# PORTLAND MAINE

September 14, 2009

Re: 51 Congress Street – 014 K009 – R-6- deck – permit #09-0847

**PROPOSED DECK AT
51 CONGRESS STREET
IN PORTLAND, MAINE**
PAGE 2 OF 2
By Anthony Taylor
in consultation with
Joseph H. Leasure, P.E.
JULY 10, 2009

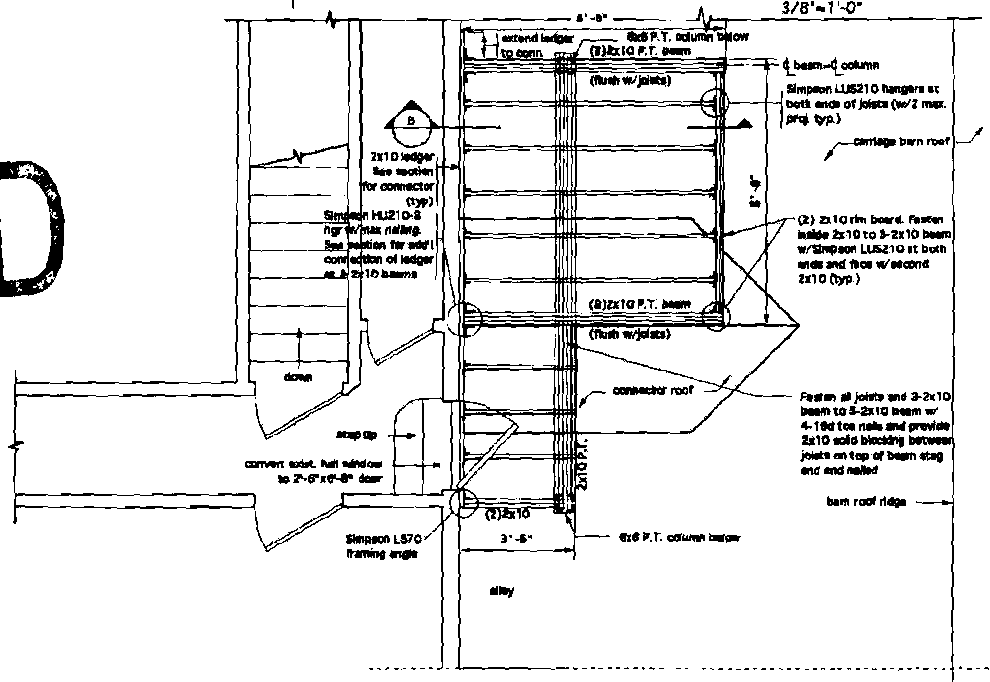
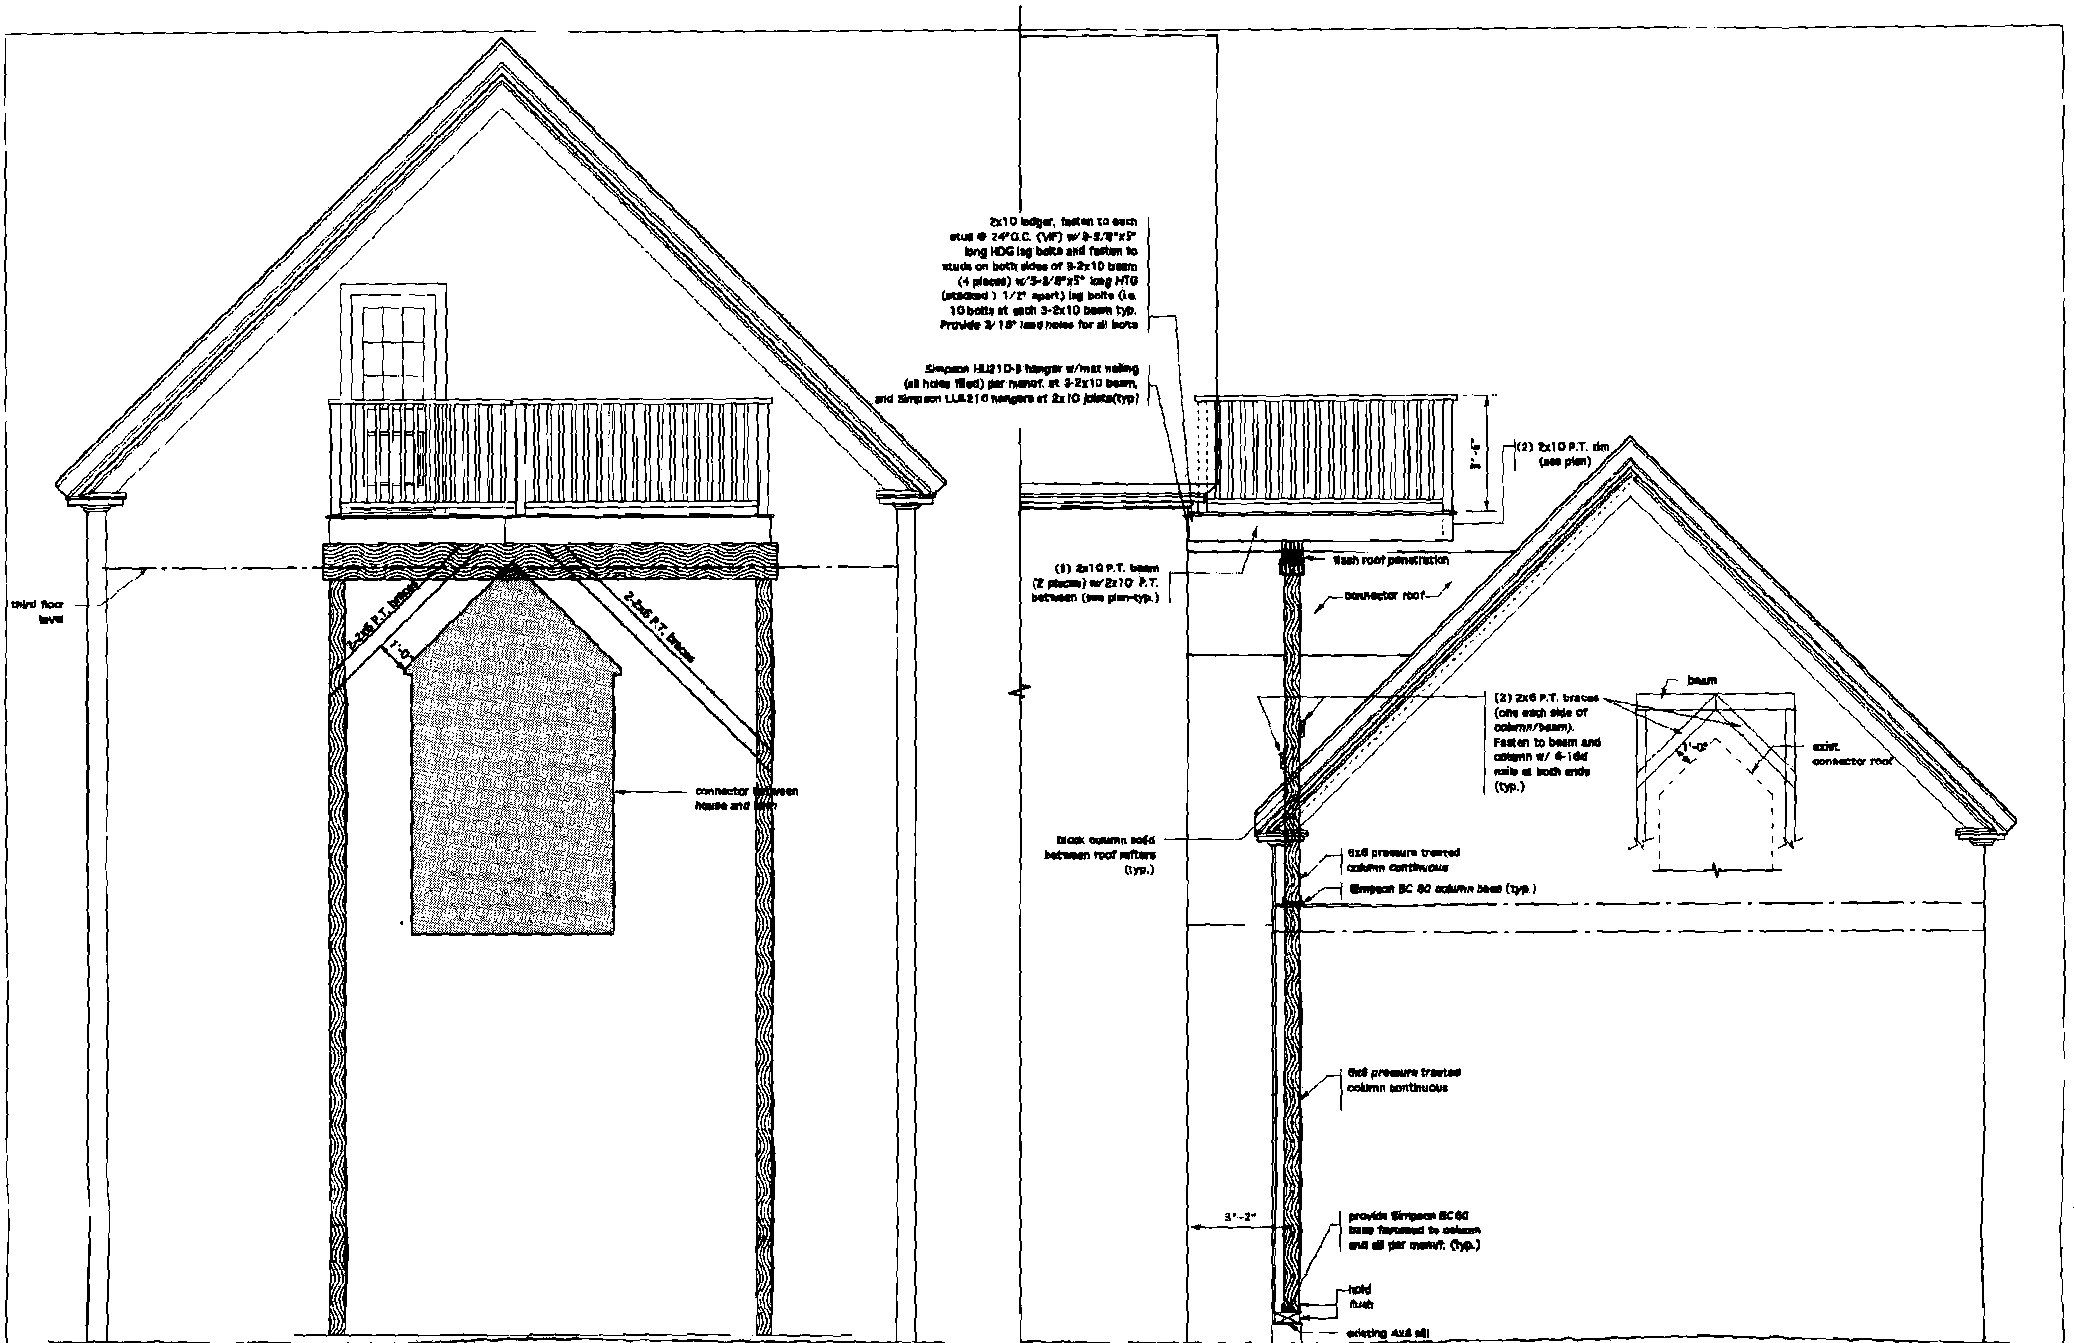
I have reviewed the building application to add an 8' x 8' deck and a 3'6" x 5'6" landing off the third floor of the rear of the building extending over the existing barn. The proposed addition does not meet the lot coverage, so I must deny the application.

51 Congress Street is located in the R-6 residential zone. Section 14-139(d)(3) gives the side setback for a three story structure as 10'. The setback given for the distance from the right side property line to the proposed landing is 9'. Although 10' is required, section 14-433 allows the side setback to be reduced to 5' for an addition if the principal structure existed as of July 19, 1988 and the normal applicable yard requirements can't be met. Since the landing needs to be at 9' because of the existing conditions of the third floor, the side setback can be reduced to 9' under section 14-433.

Section 14-139(e) gives the maximum amount of lot coverage as 50%. The lot is 3960 square feet, so 1980 square feet of the lot can be covered by the footprint of any structure. The total footprint of the existing structures is 2296.78 square feet which is 57.9% of the lot. The proposed deck and landing would add 24.22 square feet to the footprint for a total of 2321 square feet which covers 58.6% of the lot. Since the proposed lot coverage is over the maximum allowable lot coverage of 50%, I must deny the permit.
